Subject: WA/95/18/RES Land East of Tye Lane Walberton

RE: Land East of Tye Lane Walberton

Thank you for your correspondence of 7th November 2018, advising me of an Approval of reserved matters following outline consent WA/44/17/OUT for the erection of 175 No dwellings, car parking including garages, internal access roads footpaths, parking and circulation areas, hard and soft landscaping, allotments, play areas/equipment and community orchard and other associated infrastructure and engineering works. This application may affect the character and appearance of the Walberton Village Conservation area application for which you seek advice from a crime prevention viewpoint.

Flat Block D

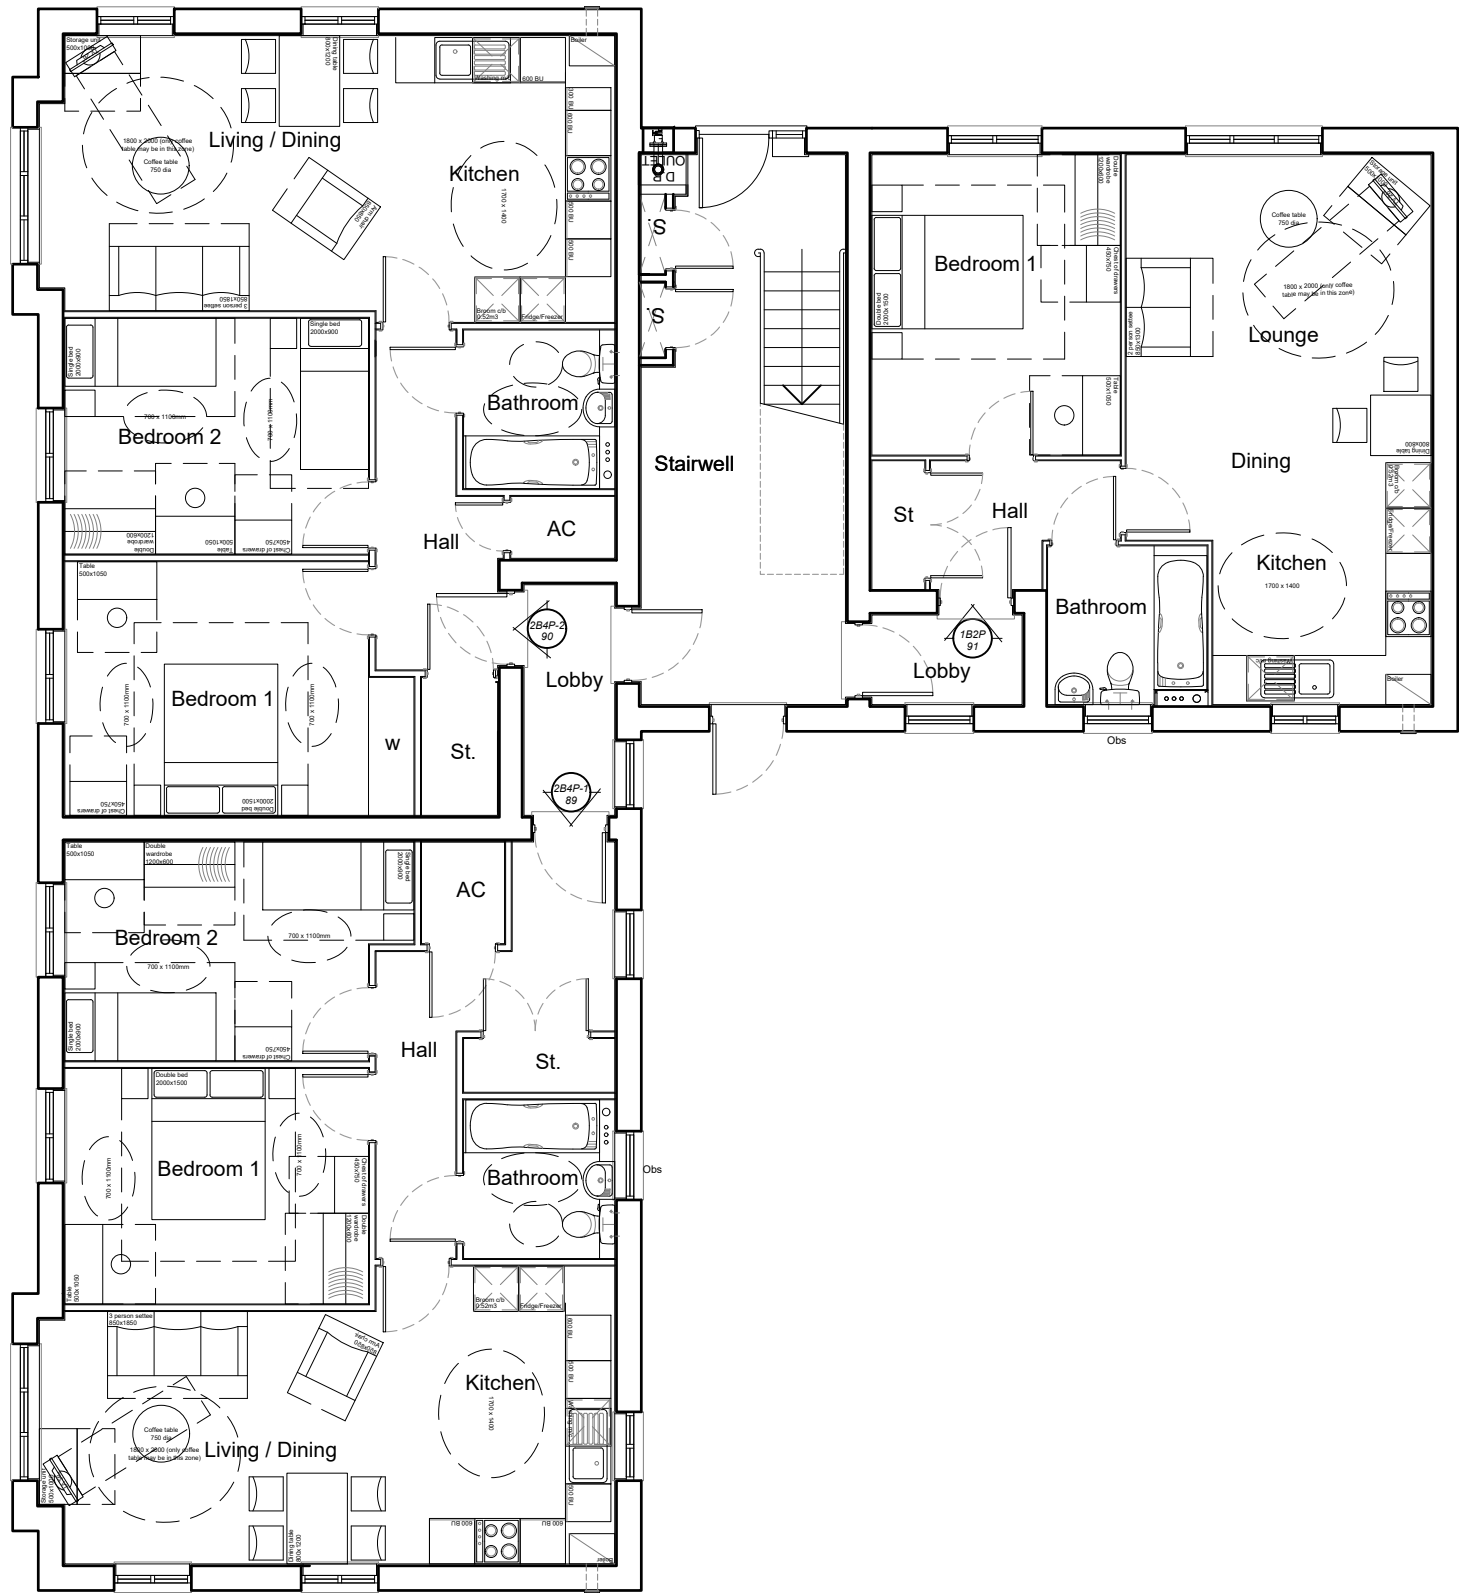
For blocks of flats D and C which each have 6 dwellings, Chapter 27:7 of SBD (Homes 2016) recommends that smaller developments containing up to 25 dwellings or bedrooms shall have a visitor door entry system. The technology by which the visitor door entry system operates is a matter of consumer choice, however it should provide the following attributes: Access to the building via the use of a restricted electronic key fob, card or key.

Remote release of the primary entrance door set from the dwelling or bedroom.

Audio and visual communication between the occupant and visitor.

Trades persons release mechanisms are not permitted as they have been proven to be the cause of anti-social behaviour and unlawful access.

Installed electronic release hardware must form part of the certified door set range. Developers and installers of door entry and access control systems should be aware that UL293 provides reassurance that a system has been assessed against a prescribed security test regime.

SBD recommends the use of colour monitors over black and white as it assists in definition, identification and identification of clothing.
